CITY OF ALBUQUERQUE

June 18, 2020

Re: Yale Retail
416 Yale Ave SE
Request for Certificate of Occupancy
Transportation Development Final Inspection
Engineer's/Architect's Stamp dated 5-16-18 (K16D011)
Certification dated 6-4-20

SHEET NUMBER
TCL-1

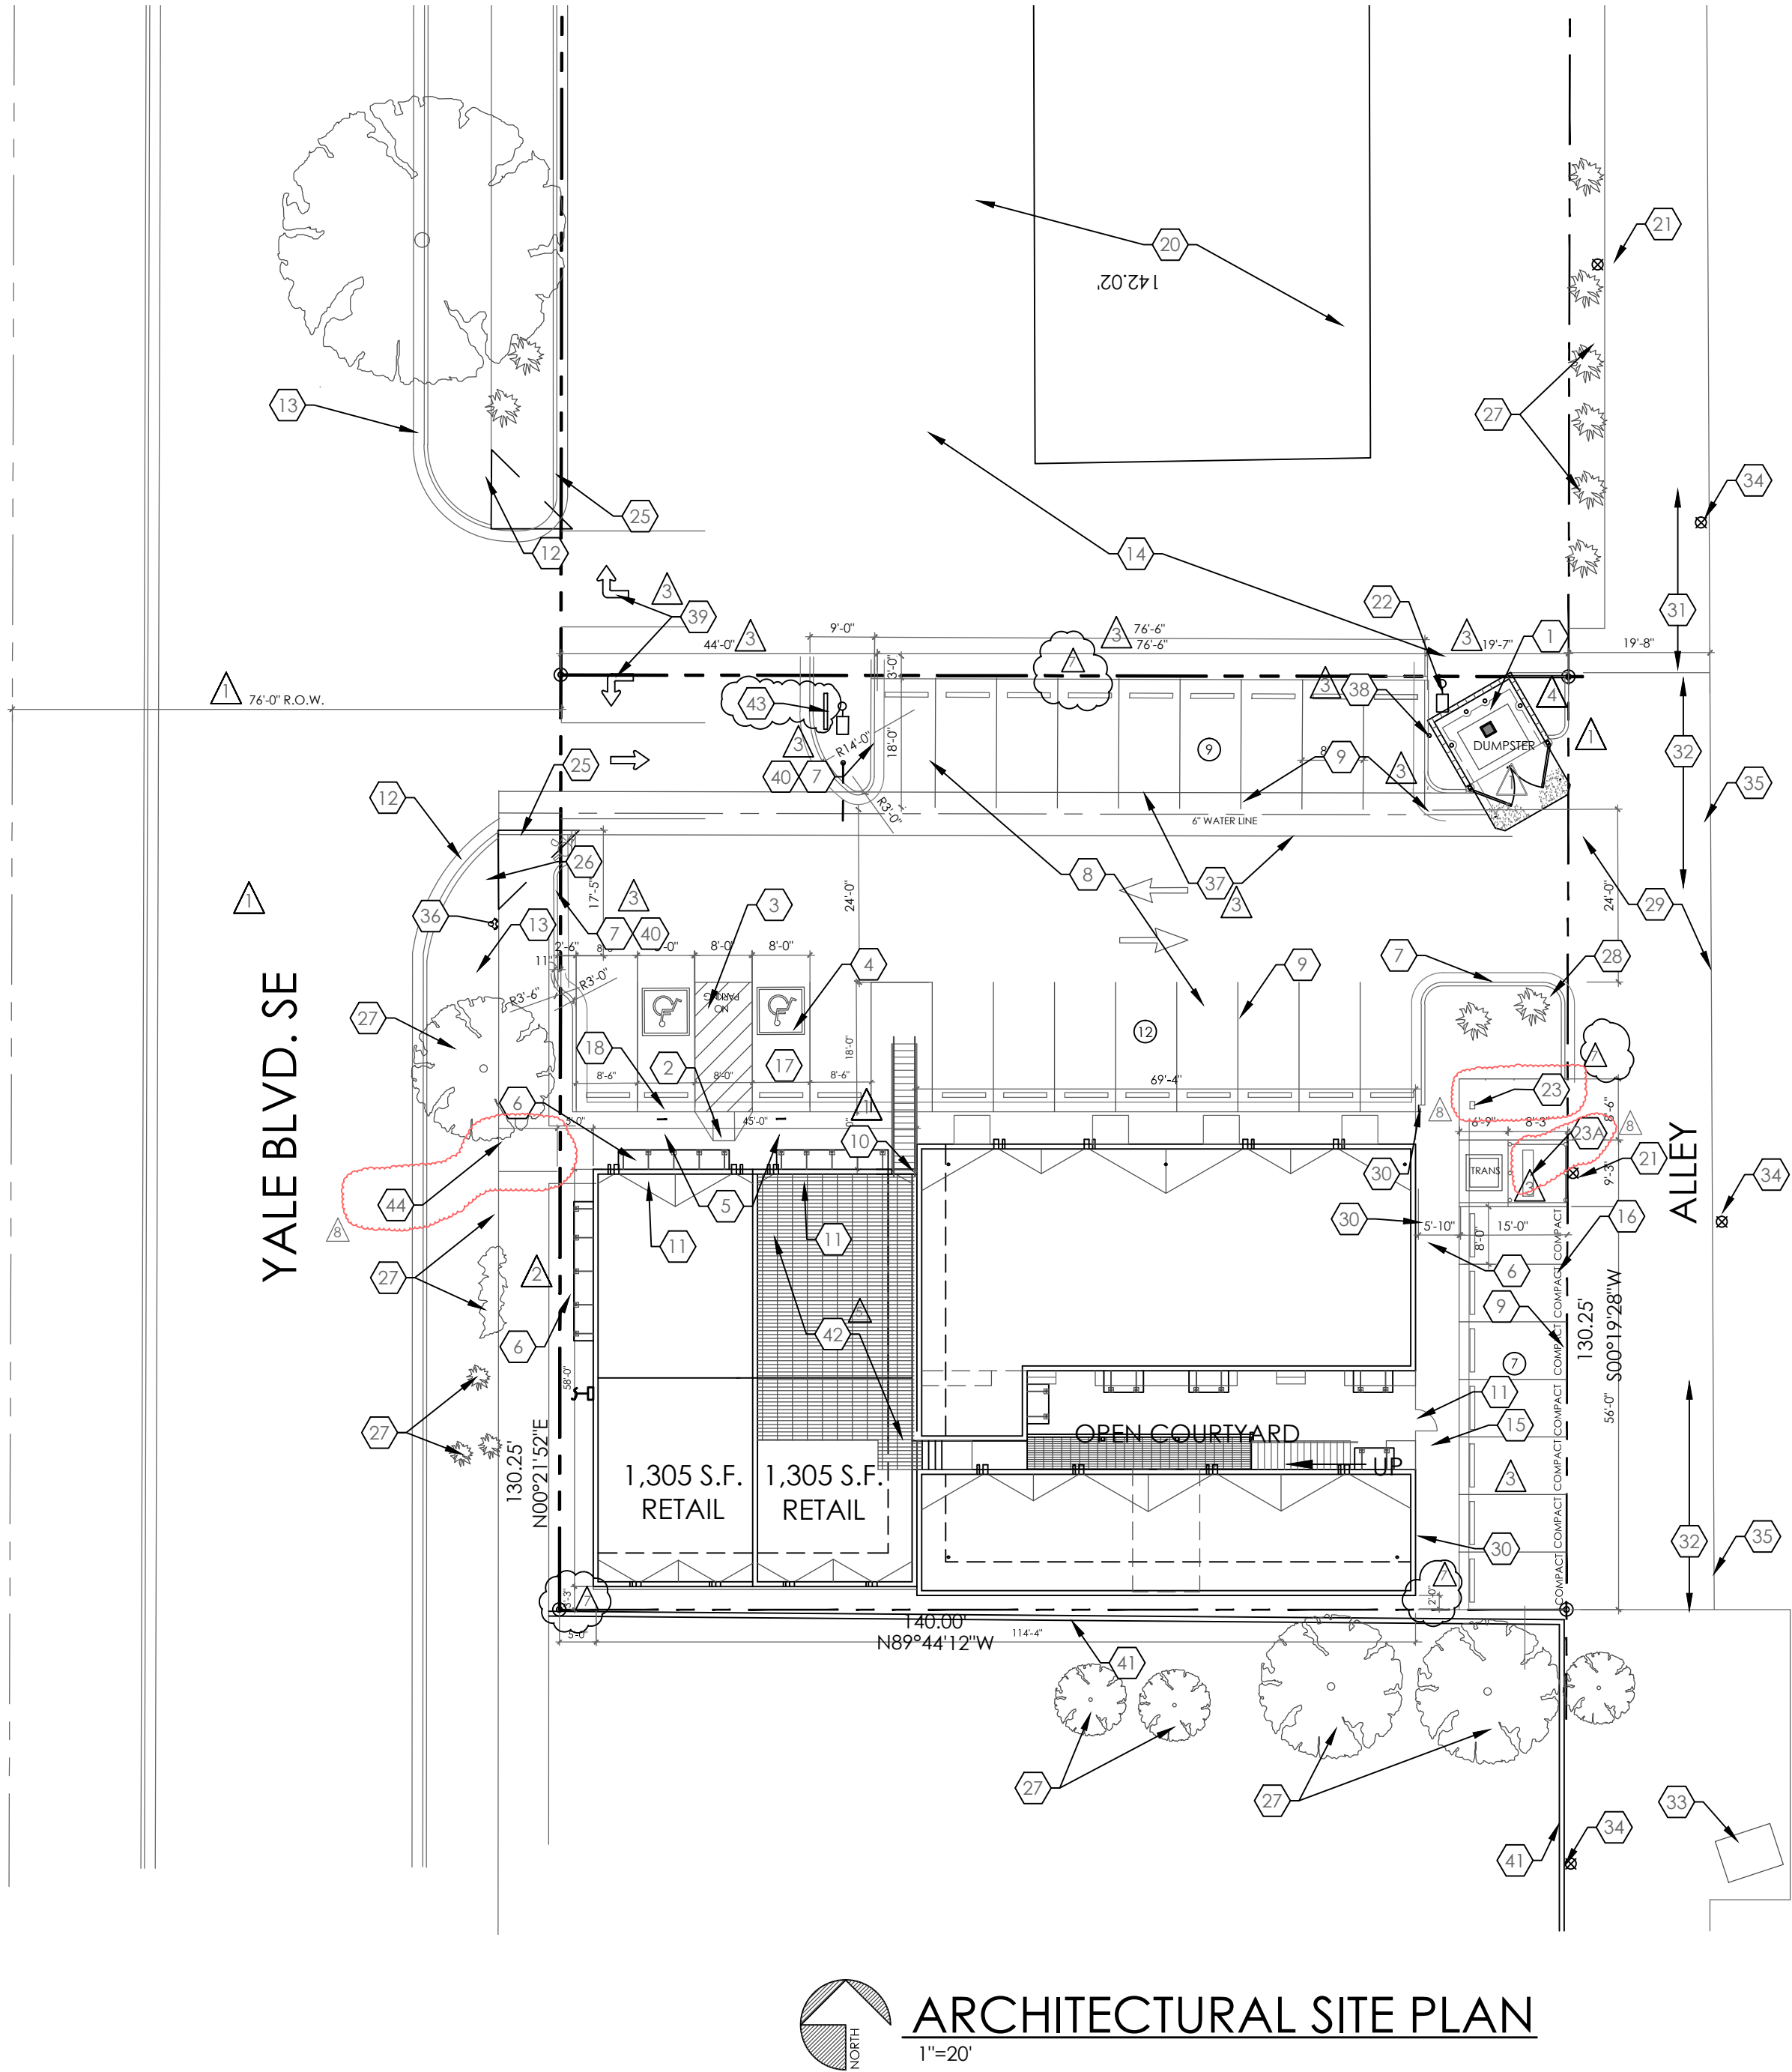
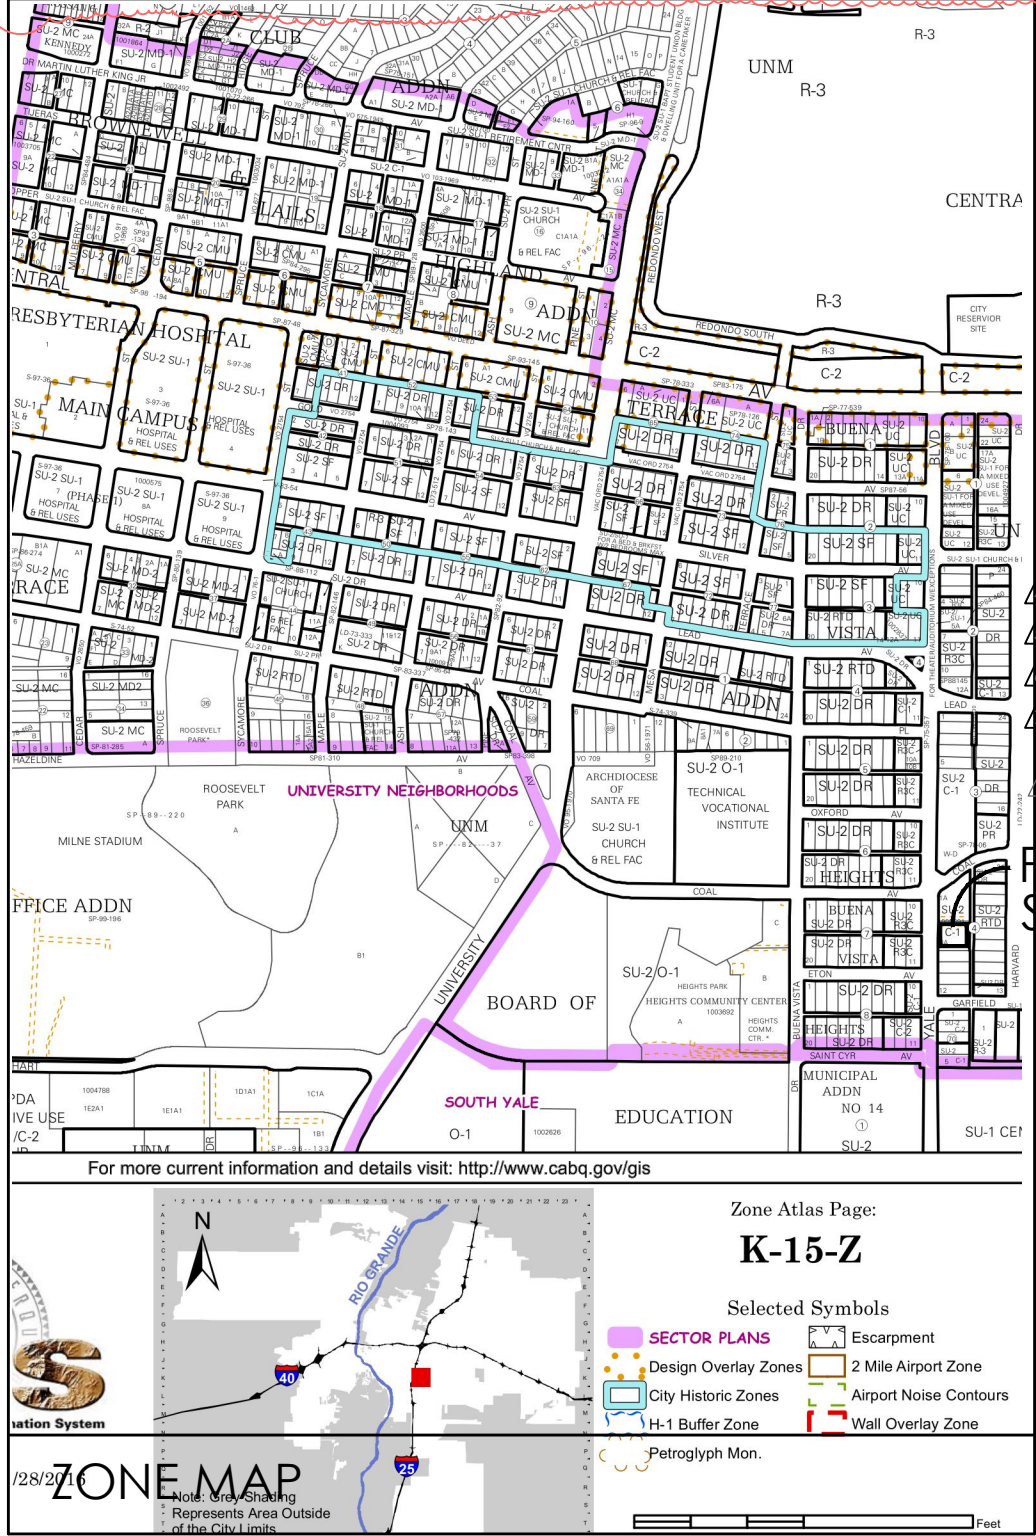
- Please redline plan to reflect changes to site.
- Bike rack does not meet city standards (See attached Bike rack standards)
- Update ADA signs to reflect current language and add parking bumpers.
- Please add work order #. Alley Paving.
- Remove compact from motorcycle stall and stripe for two MC stalls.
- Add concrete connection from sidewalk to Building entrance for ADA access. (Maximum running slope 8.0% Max cross slope 2.0%)
- Remove trash container next to compact stall.
- Water meter is located within compact parking stalls. Are the meters Traffic rated? Please contact Water Authority.
